Application by EPL 001 Limited: Stonestreet Green Solar Project (Application Reference: EN010135)

Responses to Section 51 Advice and Section 55 Checklist

Appendix 1- Responses to Section 51 Advice and Section 55 Checklist

Project Name:  
 Stonestreet Green Solar  
 Drawing Title:  
 Illustrative Layout Plan  
 Sheet 2 of 5  
 Drawing Number:  
 142-02-01-pg2  
 Scale: 1:2,000@A1 APFP Reg. 5(2)(a)  
 Produced: RC Checked: Quod Date: November 2024 Version: 02

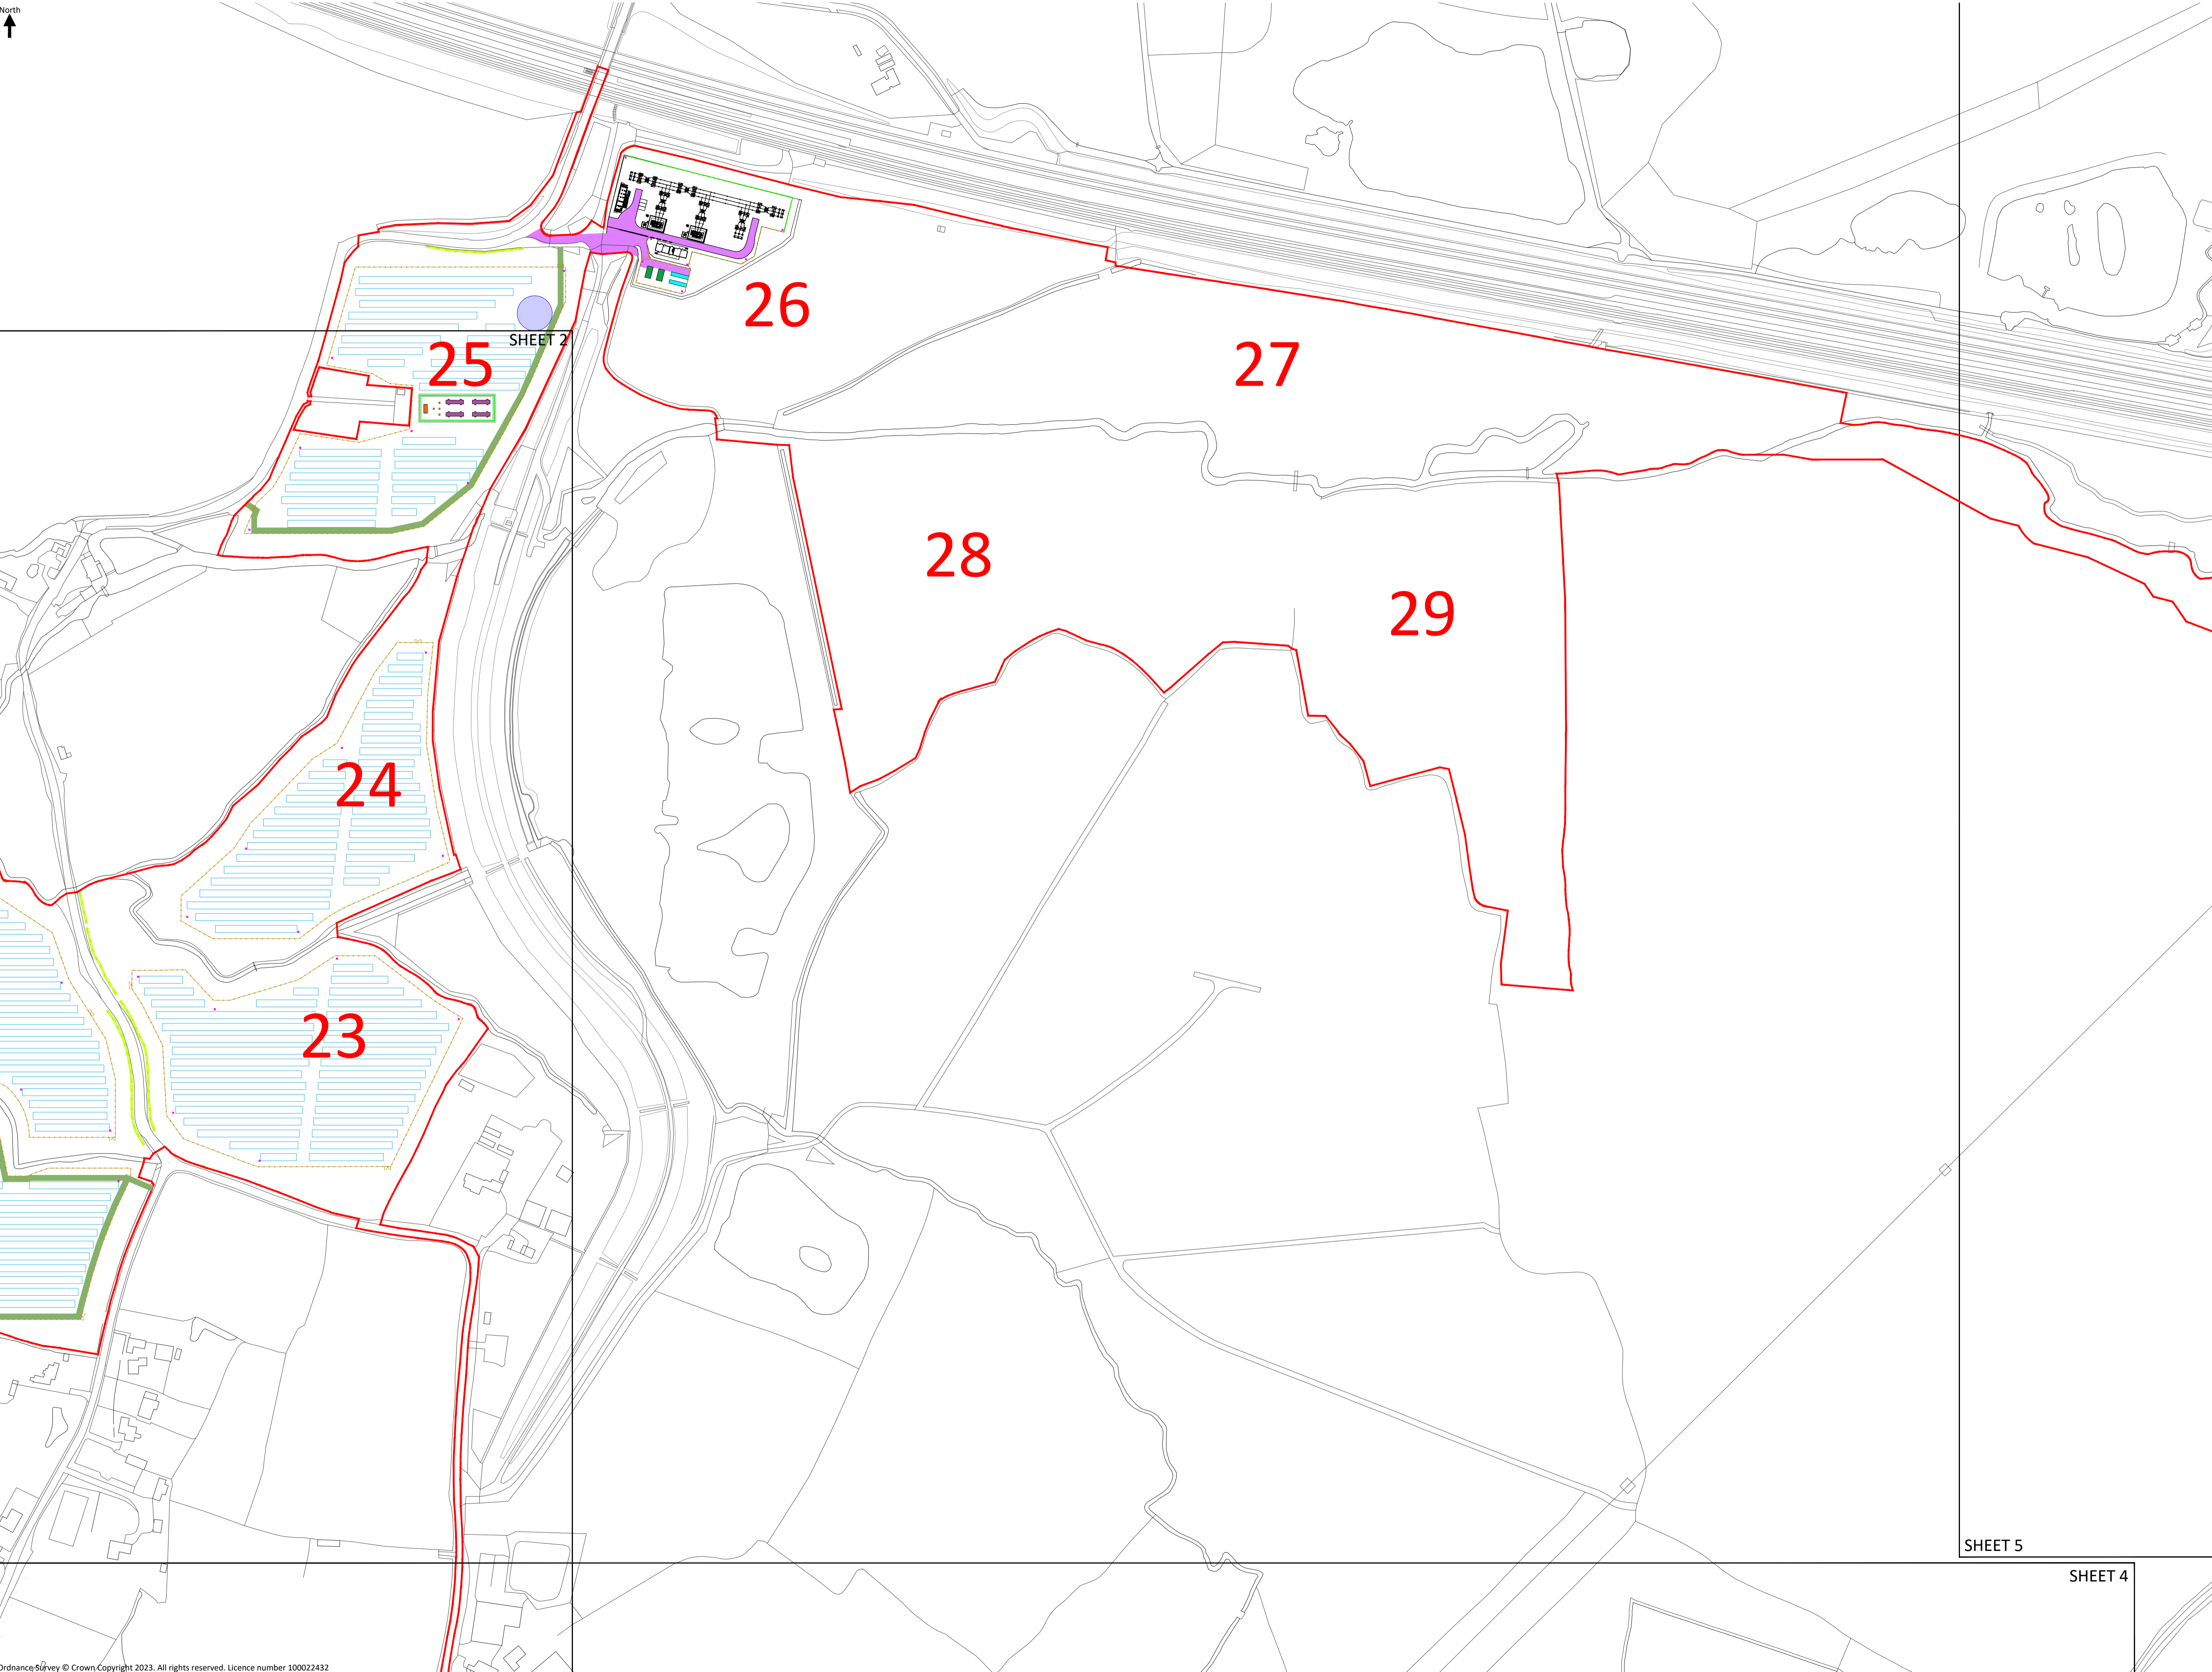
Section 51 Advice	Response
<p>Please can the Applicant clarify what area would be enclosed by the Stock Fence in Field 29 relating to the Illustrative Project Drawings not for approval Sheet 3 of 5 Illustrative Layout Plan (Doc 2.6).</p>	<p>Please note that we understand this comment relates to the Illustrative Landscape Drawings (Doc Ref. 2.7).</p> <p>This area of Proposed Meadow Grassland is intended for nesting bird habitat areas. This is why the area is enclosed by a Stock Fence. The Stock Fencing provides protection from walkers and dogs.</p>
<p>Once the plans have been amended in accordance with the advice in this letter, please submit a copy of all land and work plans at AO size.</p>	<p>As set out in the Application Covering Letter, the Land and Work Plans have been produced at 1:2,000 at A1 scale. This is in accordance with the Infrastructure Planning (Applications: Prescribed Forms and Procedure) Regulations 2009 (as amended), as discussed with PINS during the pre-application stage. The scale and paper size used is consistent with other Solar DCO applications, including the Longfield DCO application and the Applicant therefore has not included plans of this size as part of this response.</p>
